BRADLEY POINT FILING NO. 1

CONSTRUCTION PLANS

BRADLEY POINT FILING NO. 1		COVER SHEET	
PROJECT NO. 70-074	SCALE: HORIZONTAL: N/A VERTICAL: N/A	DATE: 08/31/2023	SHEET 1 OF 8 CD01
DESIGNED BY: DM	DRAWN BY: CUP	CHECKED BY: DM

POND 1 SITE PLAN (PRIVATE)
SCALE: 1"=10'

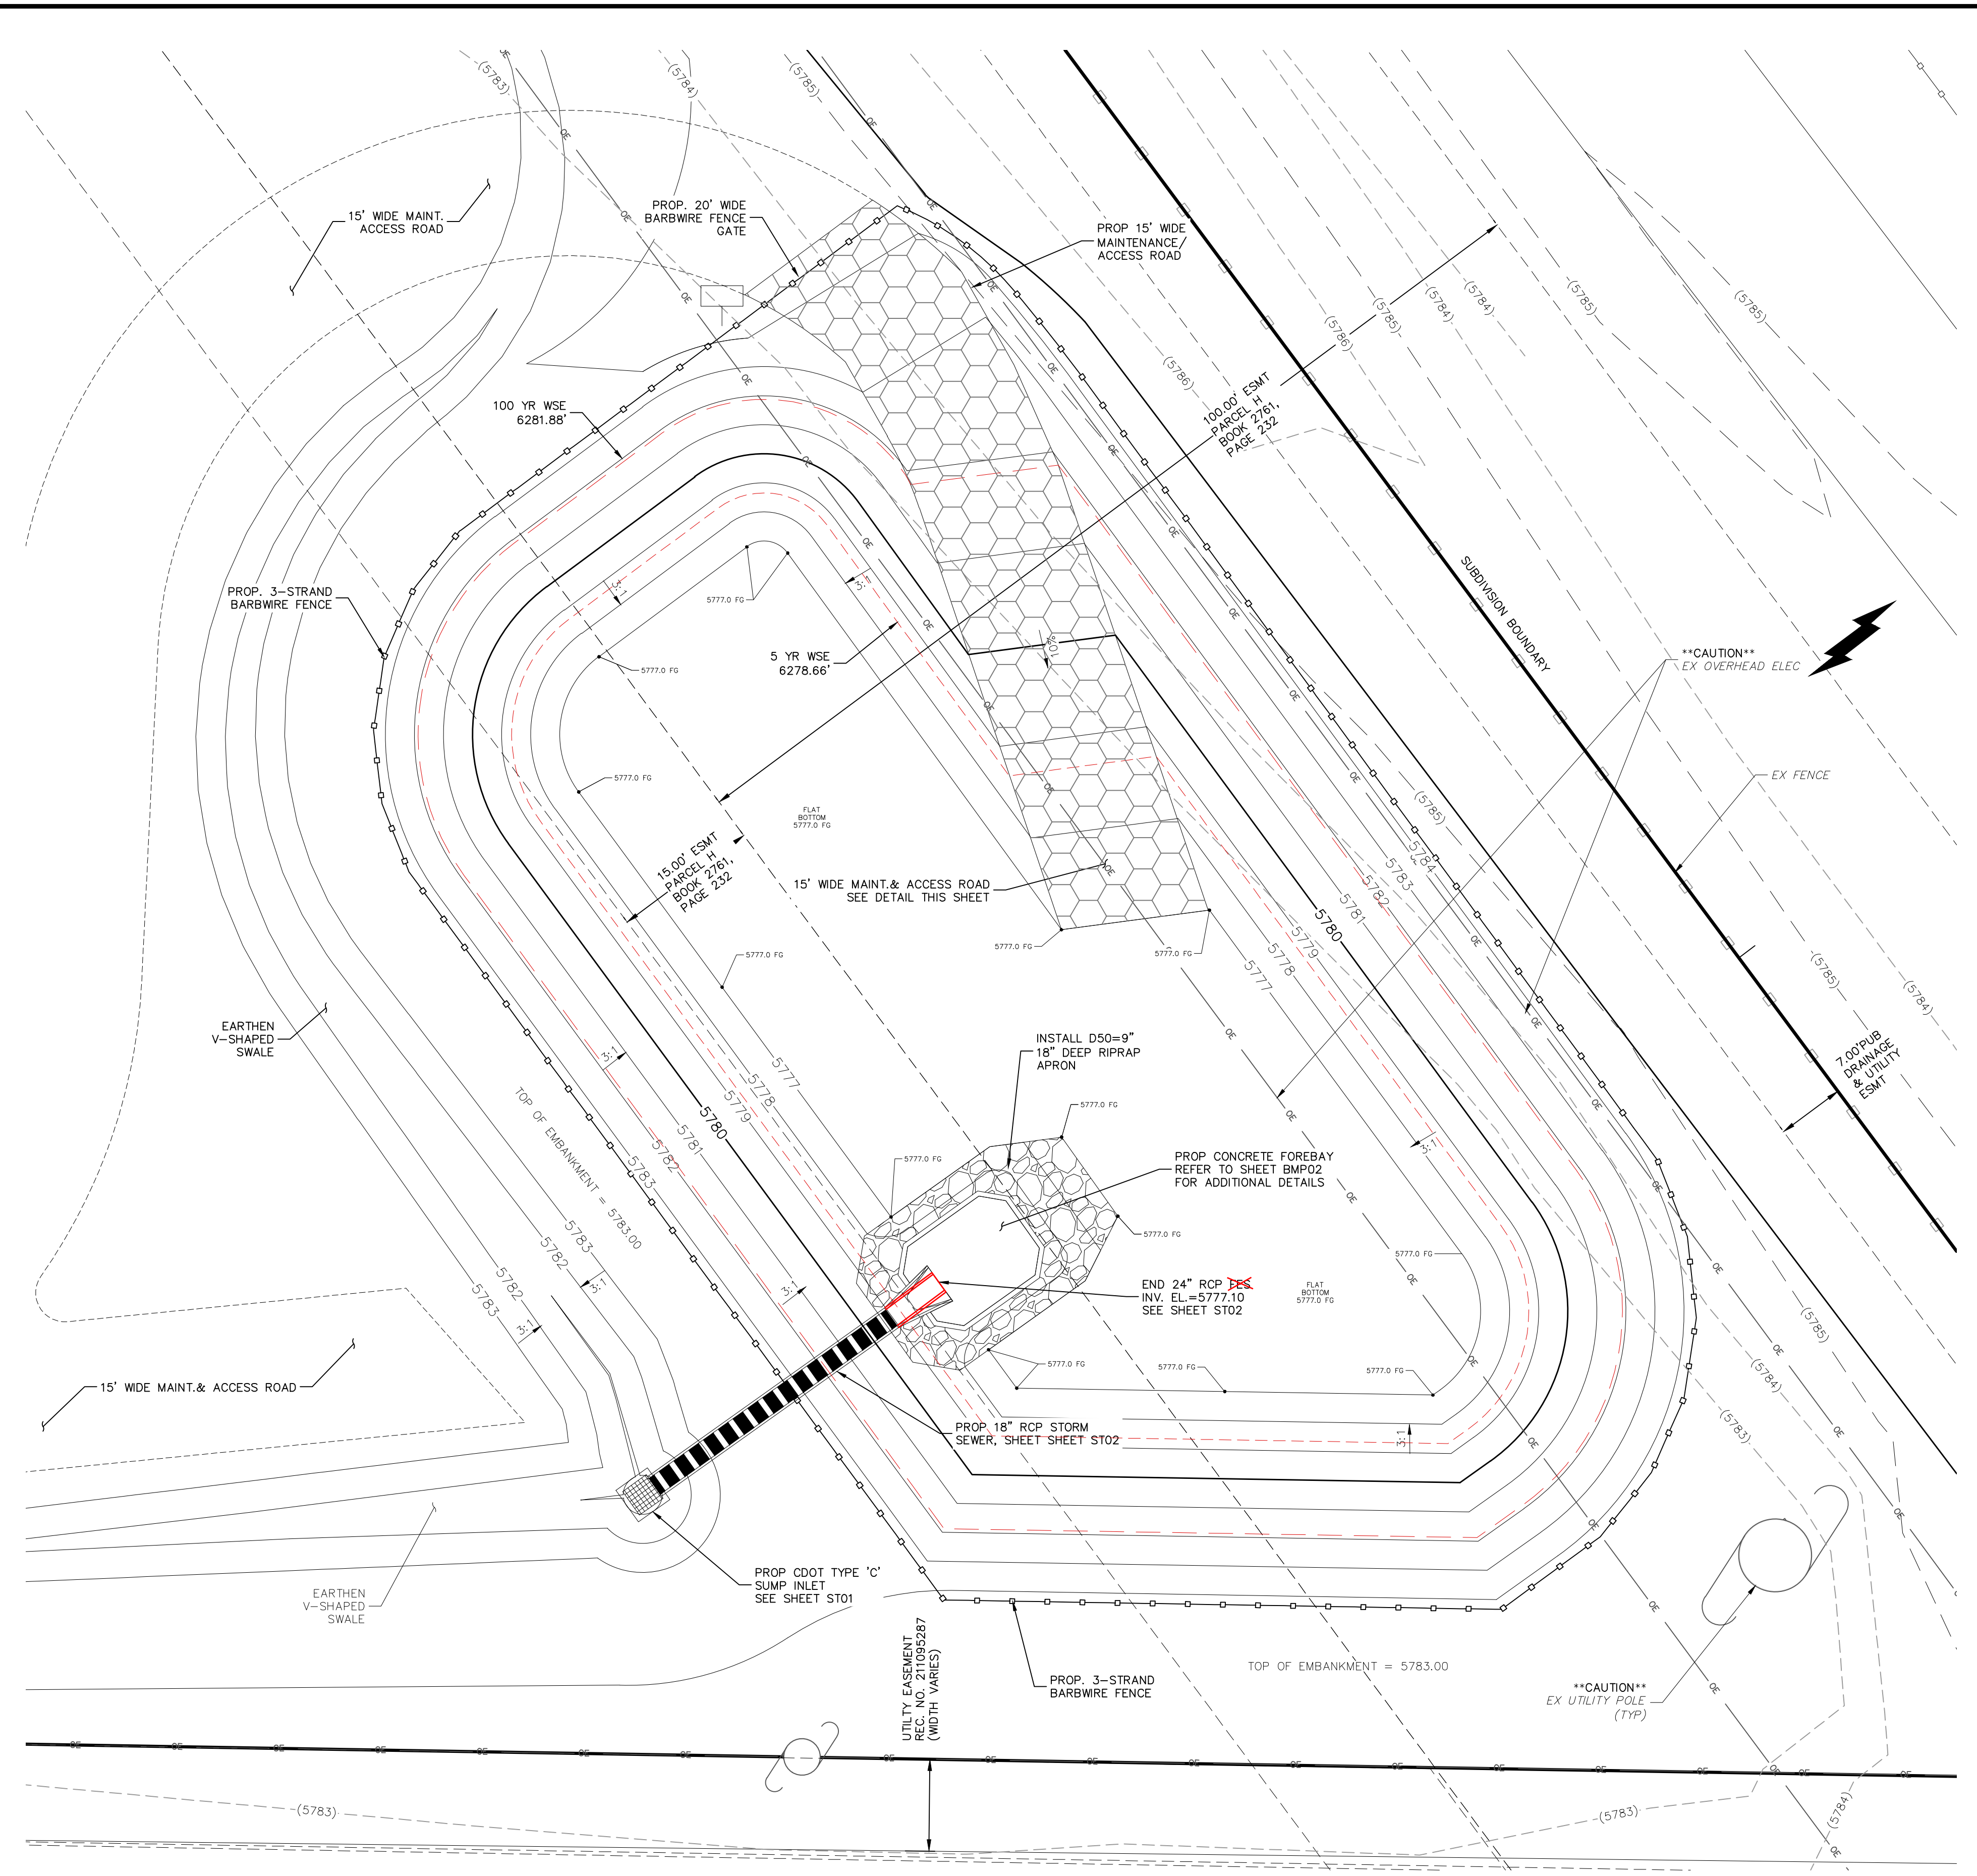
This proposed swale was not installed in the field. Please provide updated dimensions to demonstrate that all storms are still conveyed to Pond 1 effectively.

POND 1 FOREBAY
 SCALE: 1"=2'

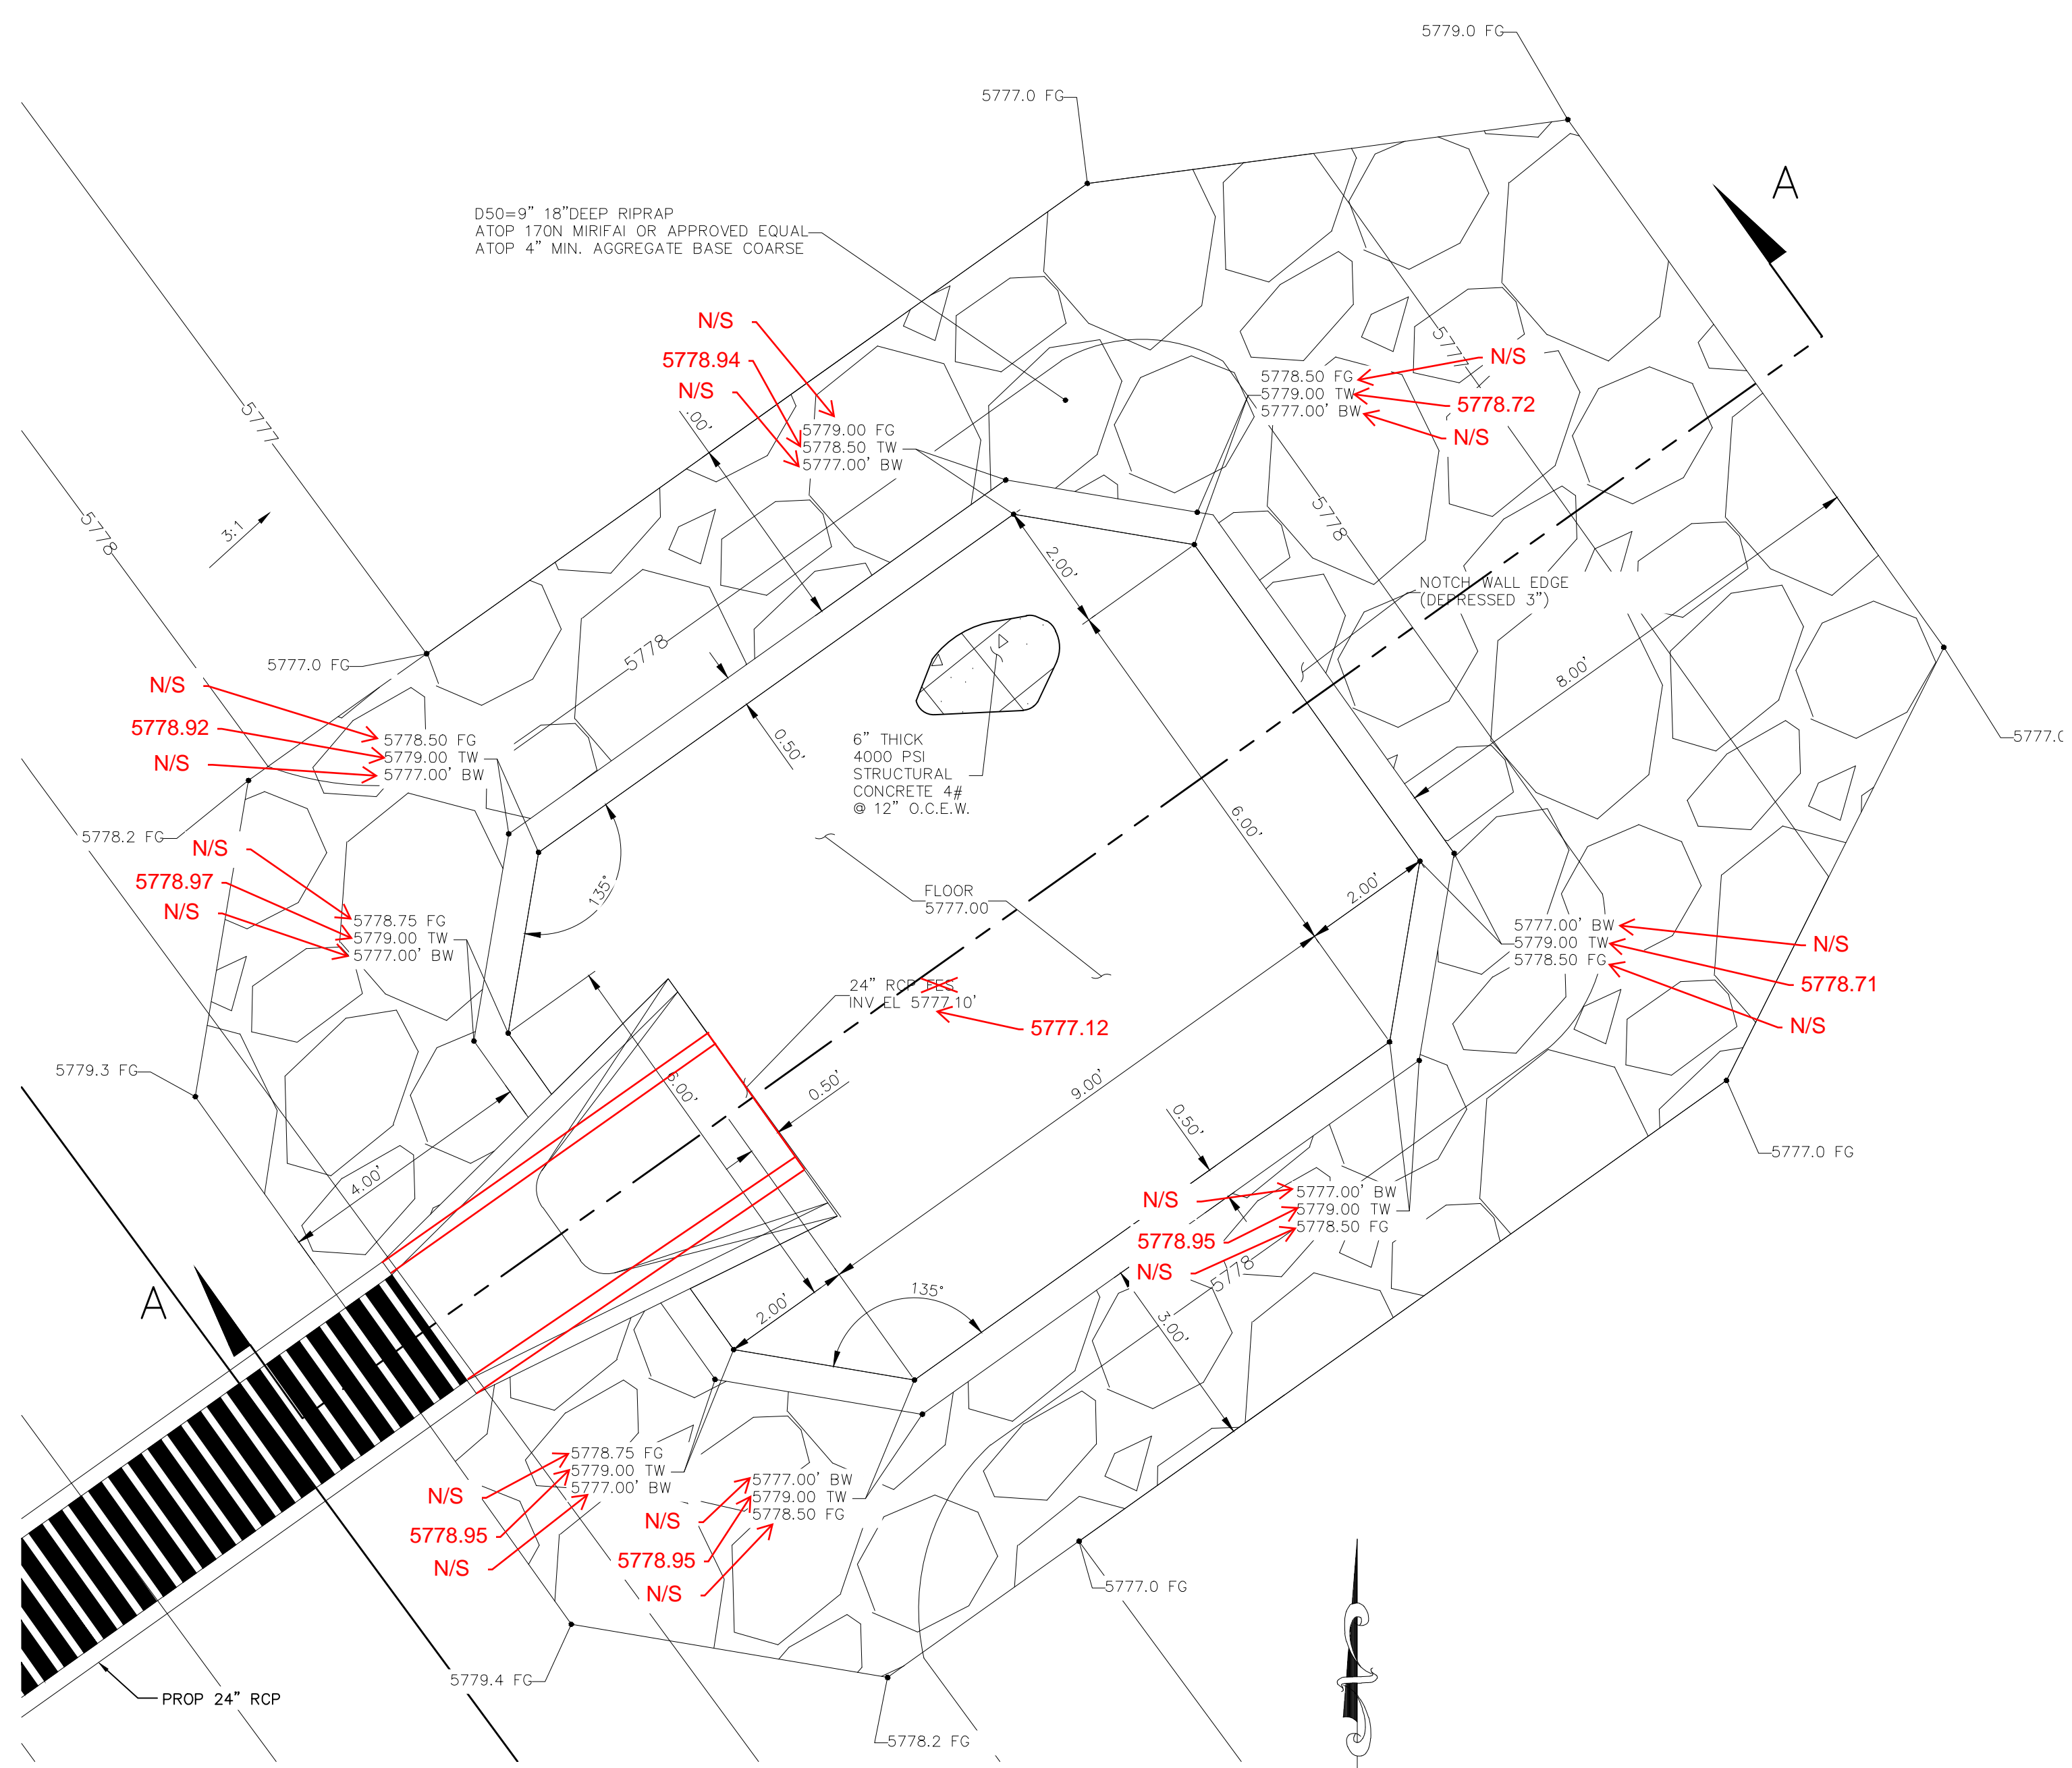
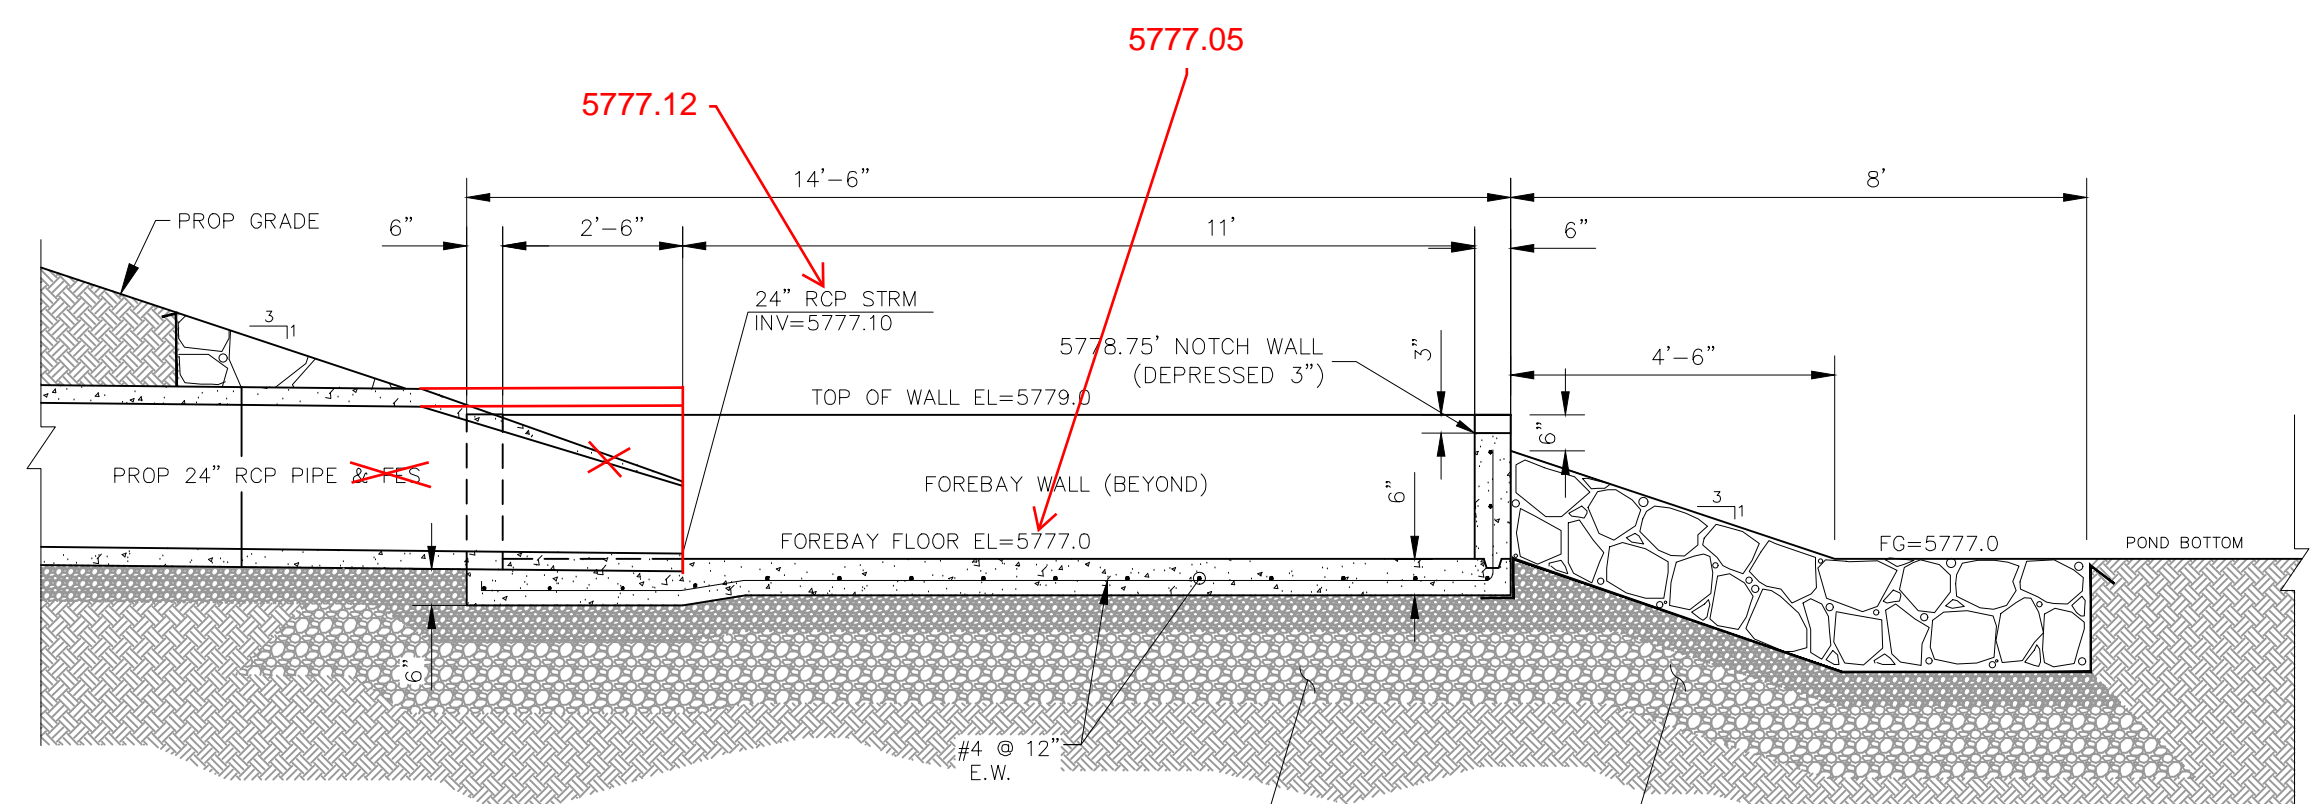
No FES was present in the field. Please callout this change.
